From: Ellie Myers
Sent: Wednesday, January 28, 2026 9:09 AM
To: corey@wardrugh.com; karrine.rogers@gmail.com; brian@piperbuilds.com
Cc: Jamey Ayling; Zach Torrance-Smith; Bradley Gasawski; Ellie Myers
Subject: SX-26-00002 Rogers - Request for Information

Upon further review of this property, there appears to be a discrepancy between the site plan and the Ordinary High-Water Mark (OHWM) of Manastash Creek.

ROGERS GARAGE
221 WOODSCREEK LANE
ELLENSBURG, WA 98926

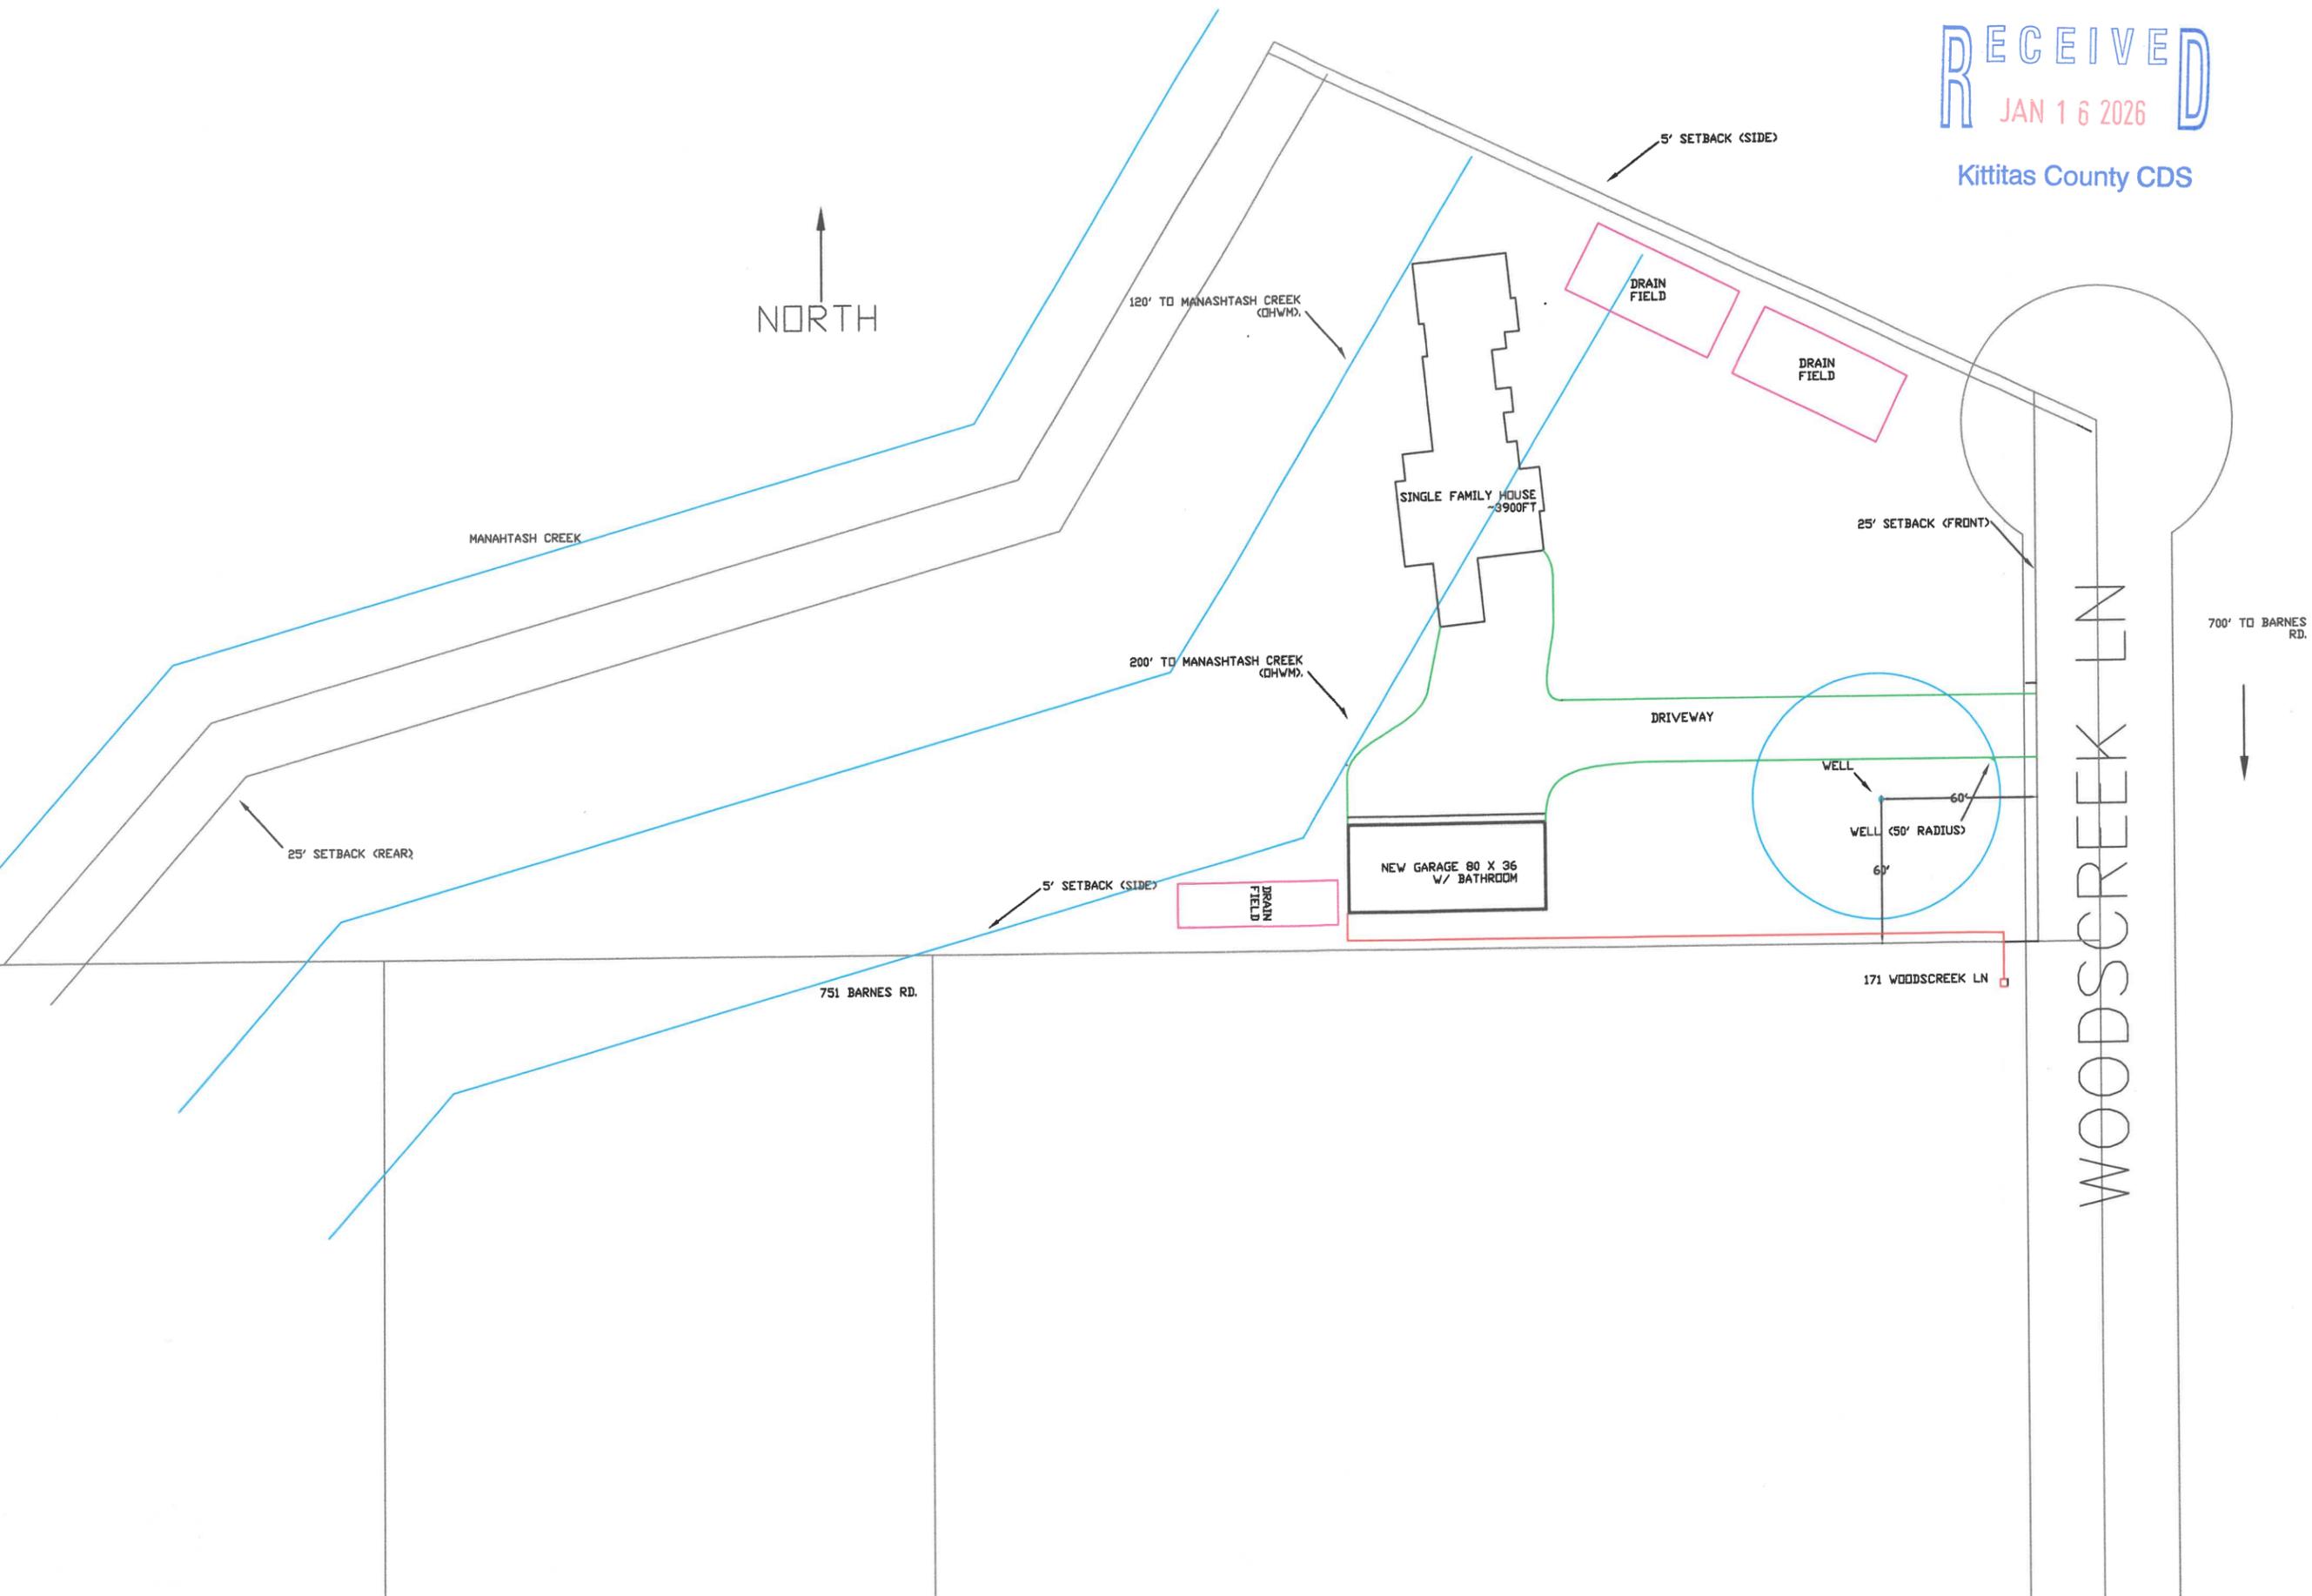
The site plan provided shows the edge of Manastash Creek coinciding with the parcel boundary. To complete the Shoreline Exemption, an updated site plan showing the true extent of the creek's OHWM is required. Fish and Wildlife will come out to help determine the OHWM and flag its location so you can accurately measure the 115-foot buffer and 200-foot shoreline jurisdiction. (Jennifer Nelson WDFW, 509-961-6639).

We may need to add the Accessory Building and its associated on-site sewage to the Shoreline Exemption if the OHWM boundary is on the property.
